To: Mackenzie Moynihan Staff Planner  
Kittitas County Development Services

June 17, 2008

From: James Repsher  
6252 Cove Road  
Ellensburg WA, 98926  
(509)607-9208

Re: B & J Preliminary Plat (LP-08-21) Craig Duncan – Applicant

B & J PLAT
PART OF SECTION 7, T. 17 N., R. 18 E., W.M.
KITTITAS COUNTY, WASHINGTON
- PRELIMINARY PLAT -

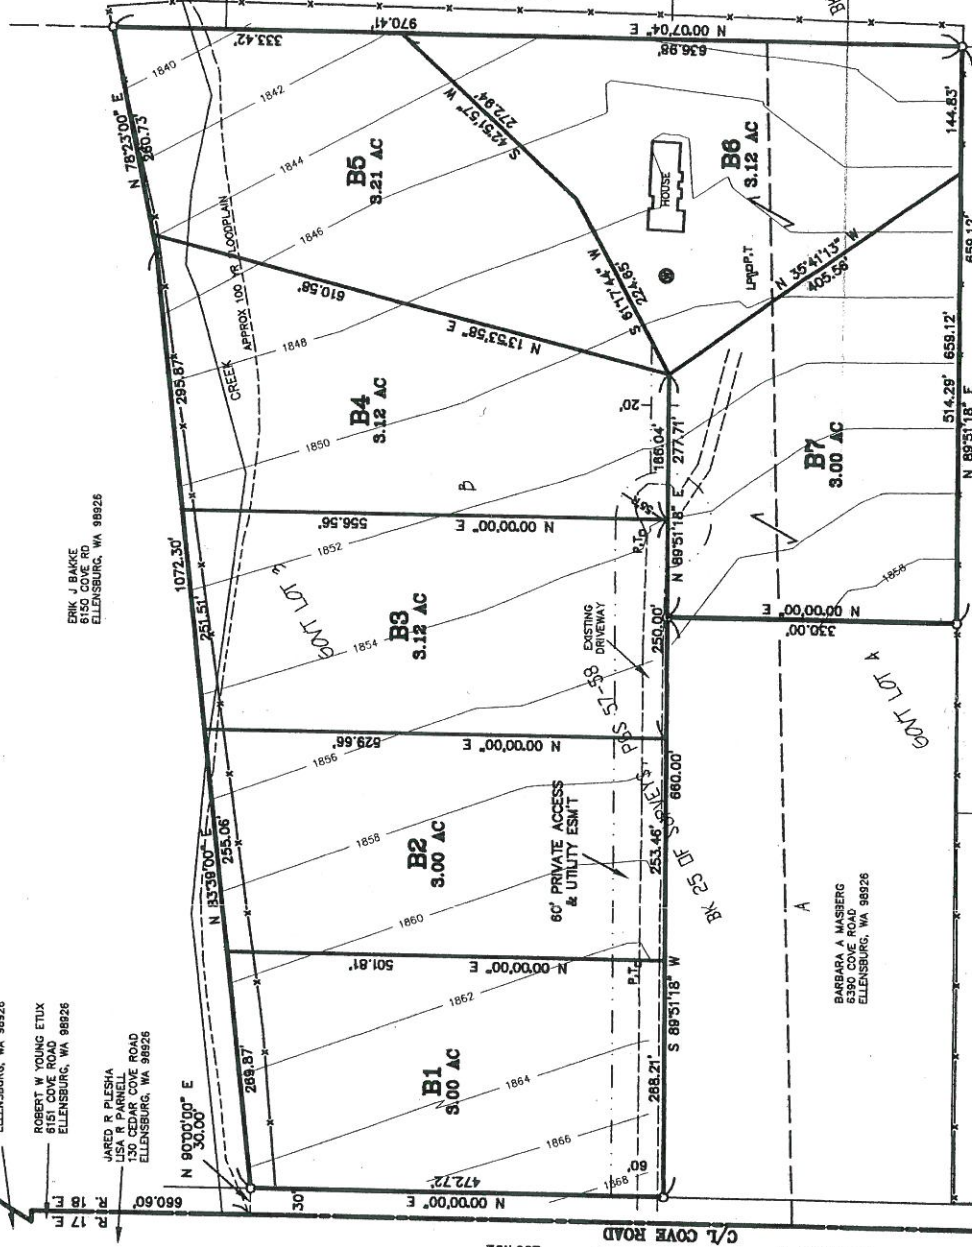
(1,g) Applicant states "minimal" land will be covered in asphalt or other hard surface. This proposed density will likely add seven large driveways and will likely require that the main private drive be paved per county code.

(3,a,6) The applicant offers no mitigation for driveway or construction runoff. He is currently using the ephemeral stream as a drainage ditch into which all current driveway runoff flows.

(3,c,1) In regards to Water Runoff the applicant states is mitigation is "Natural Absorption." There is no mention of storm runoff control to keep runoff out of the ephemeral stream or Manastash Creek.

UTILITIES: (16,a) In addition to the lack of a water supply and sewer, the applicant has no irrigation water distribution plan. As proposed, all irrigation water would have to come from a well. There is no access to KRD or other irrigation water at this site. The applicant should be required to prove the availability of irrigation water or prohibit the outside use of water at the proposed lots.

The high density of this proposal and the limited building areas on some of the lots after setbacks are considered may cause septic to well contamination between the future lot owners. A formal sewage system and/or drinking water distribution system may be required.
